Application for removal or variation of a condition following grant of
planning permission. Town and Country Planning Act 1990.
Planning (Listed Buildings and Conservation Areas) Act 1990

variations in the construction details require approval refer to drawing 2372:15revB omit approved details on drawing 2372:16

2372 : 15 B

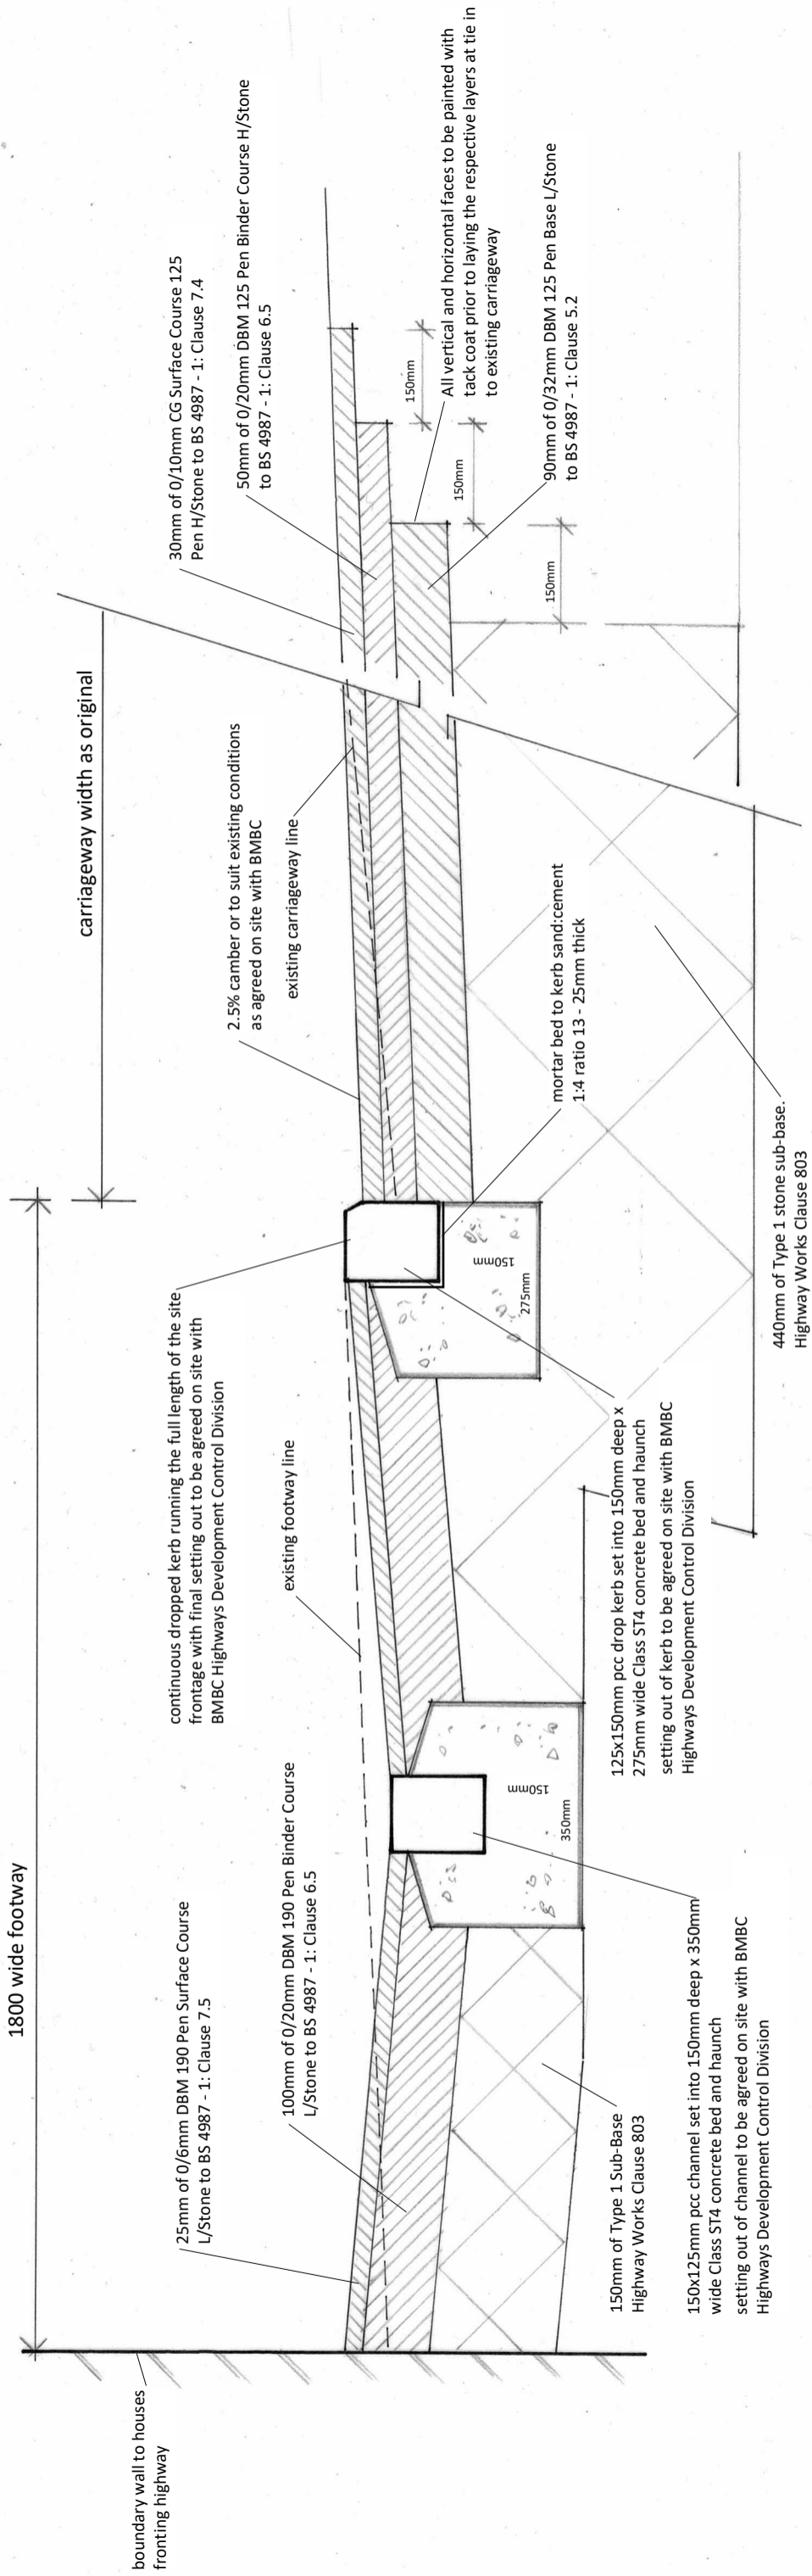
site conditions require changes to the construction of the carriageway and footway as agreed with BMBC Highway Development Control Division

the proposed construction details are at variance with those granted planning permission by discharge of Condition 10 therefore permission is required to vary the approved details
